# CITY OF ALBUQUERQUE

**Re: Route 66 Veterinary E.R. & Critical Care Center  
3601 Central Ave NE  
30-Day Temporary Certificate of Occupancy  
Transportation Development Final Inspection**  
Engineer's/Architect's Stamp dated 3-19-21 (K17D064)  
Certification dated 10-15-21

Traffic Circulation Layout

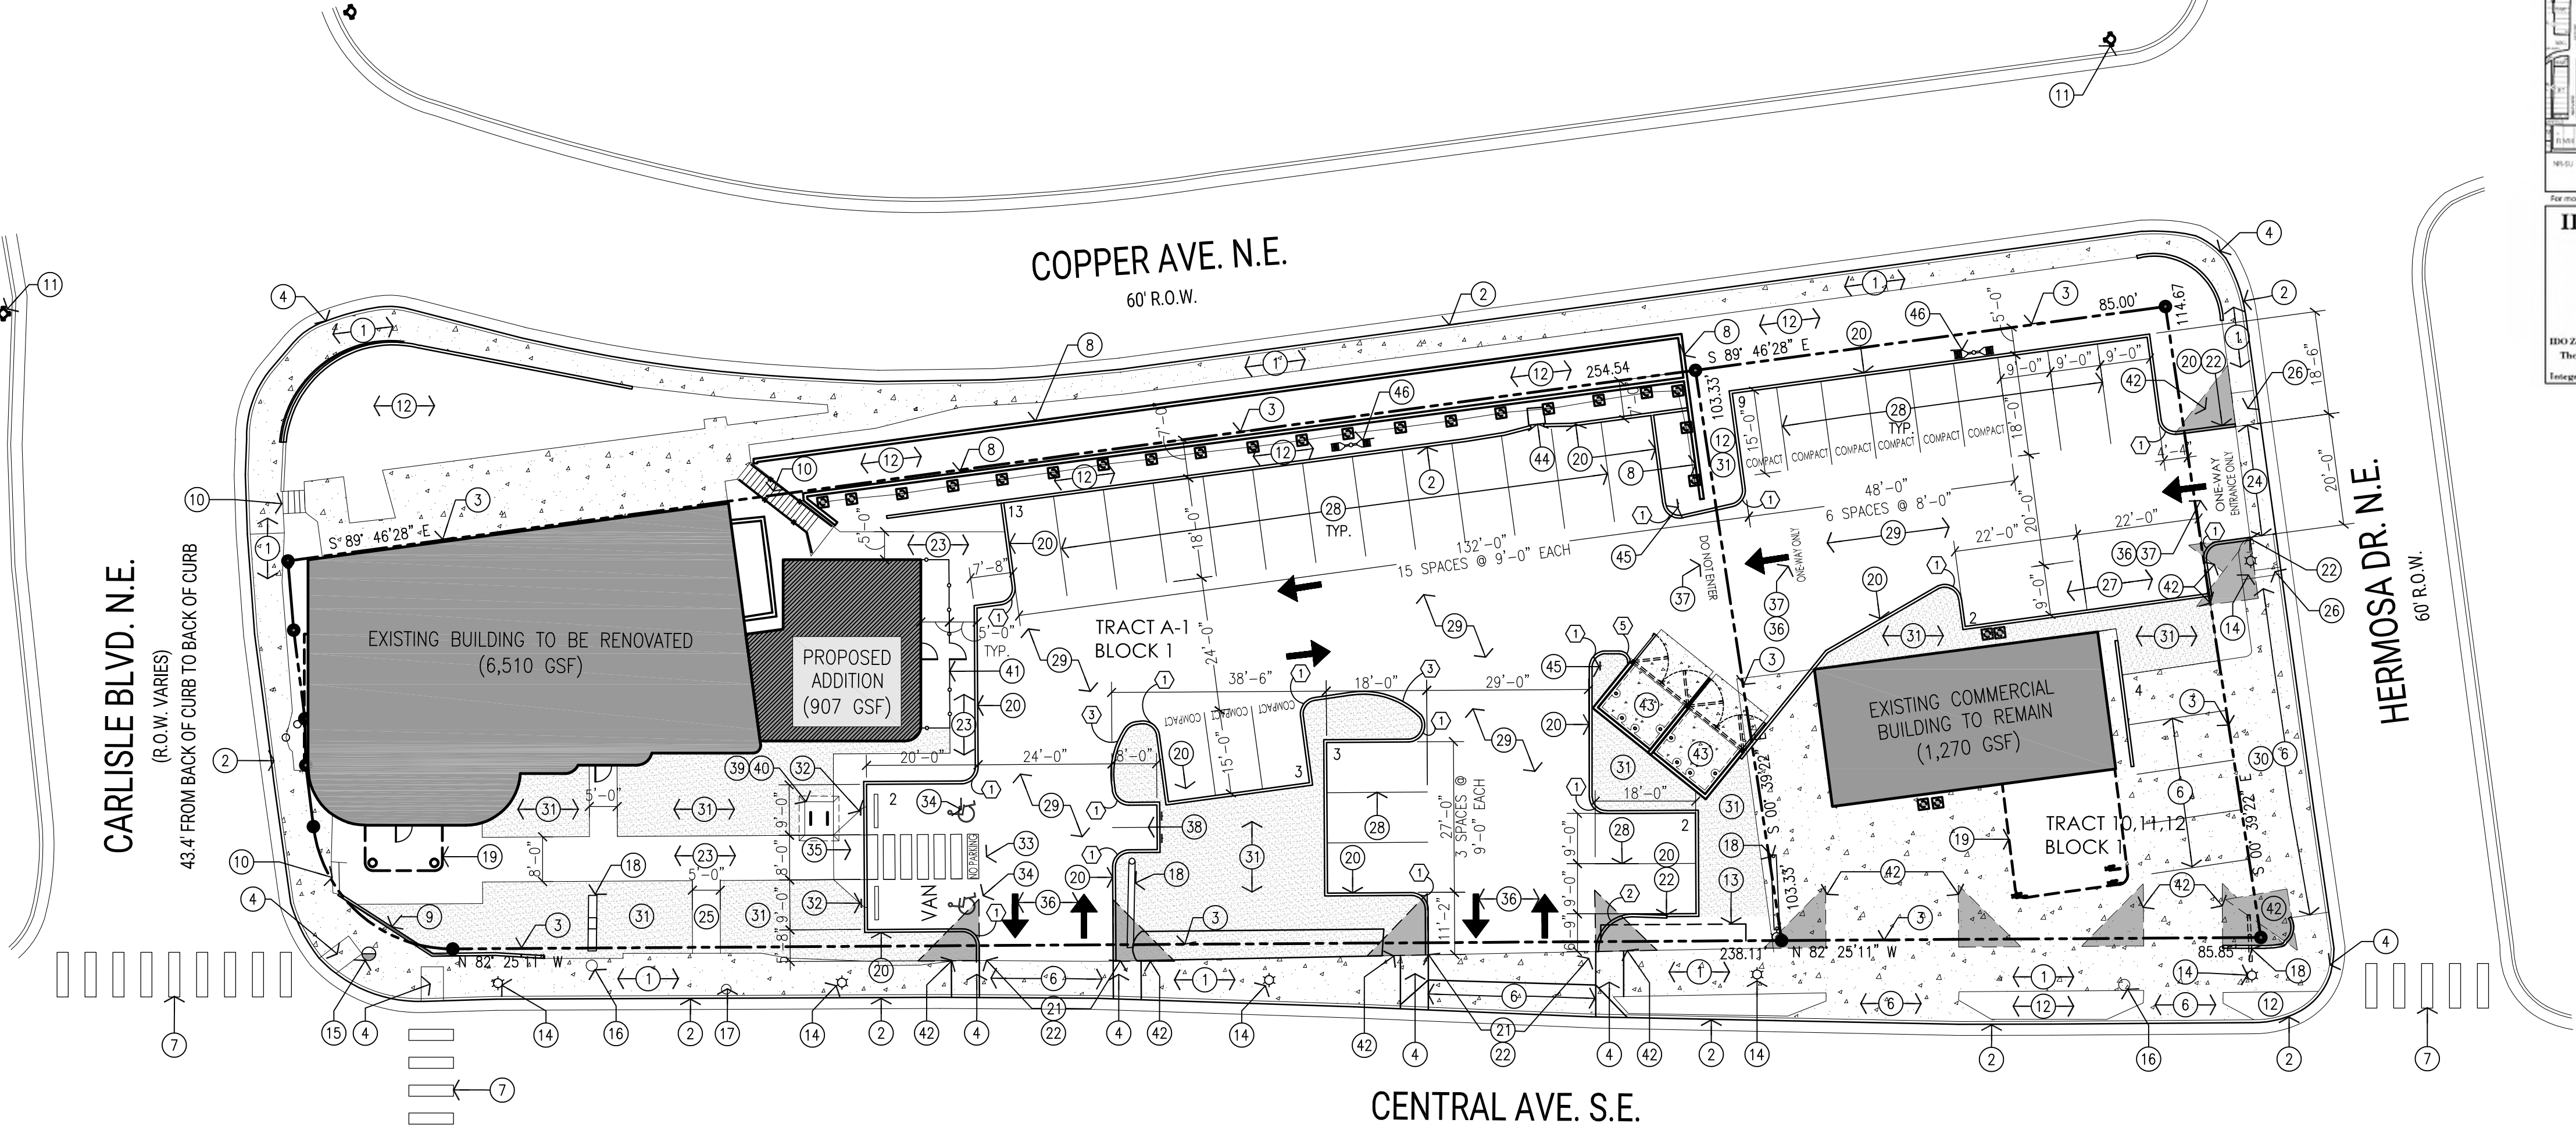
- Please complete items listed on Certification letter.
- Complete sidewalk patch off Copper.
- Complete landscaping, remove barricades, remove construction equipment and debris from site.
